From: Julie Grieves on behalf of Planning.Responses
Sent: 26 April 2012 08:14
To: Janice James
Subject: FW: Amendment to Notification re:FG/16/12/

Angmering Parish Council [REDACTED]
Sent: 25 April 2012 13:10
To: Planning.Responses
Subject: RE: Amendment to Notification re:FG/16/12/

The following are the Parish Council comments on the additional documents submitted by ASDA:

Proposed Site Plan

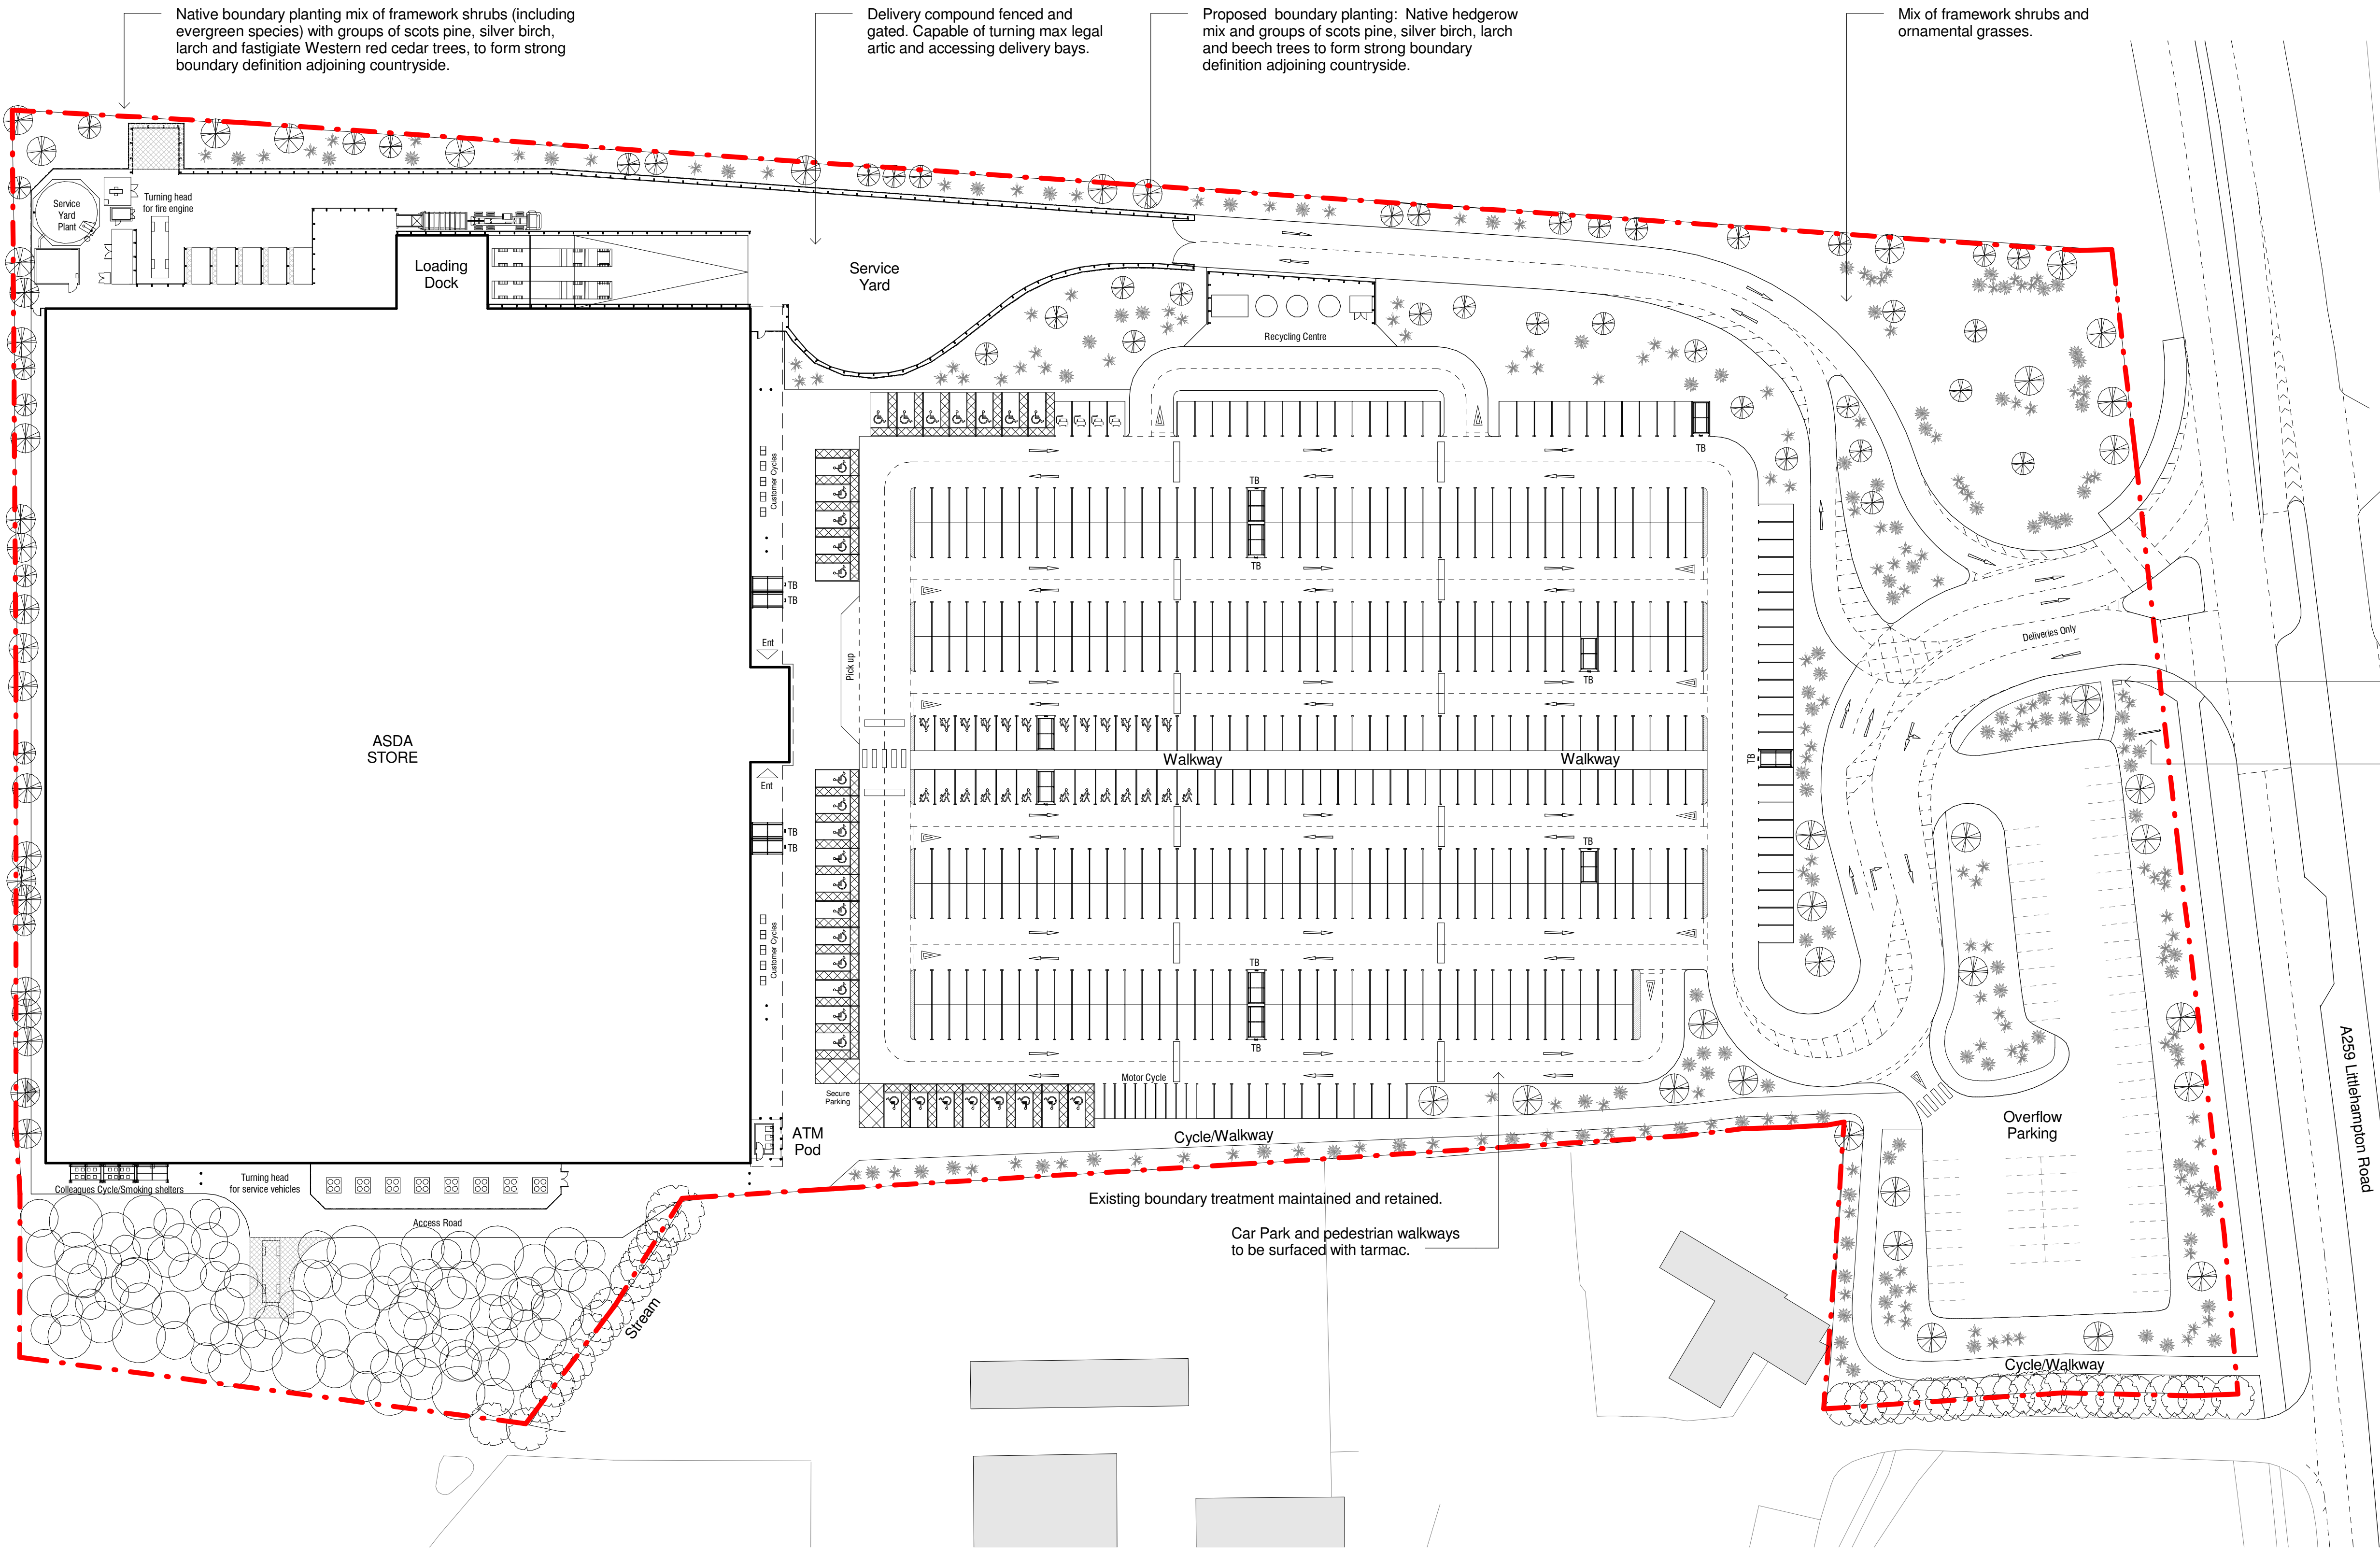
1. Landscaping - Until the planting bordering the A.259 dual carriageway has established, suitable screening should be in place to an appropriate level to provide a light barrier from the headlights of cars maneuvering in this area.

2. Lighting - Potential light pollution affecting the residential property adjacent to the car park which could have a detrimental effect on these neighbouring occupiers.

3. A further identified potential issue would be the impact of vehicle emissions on this adjoining property.
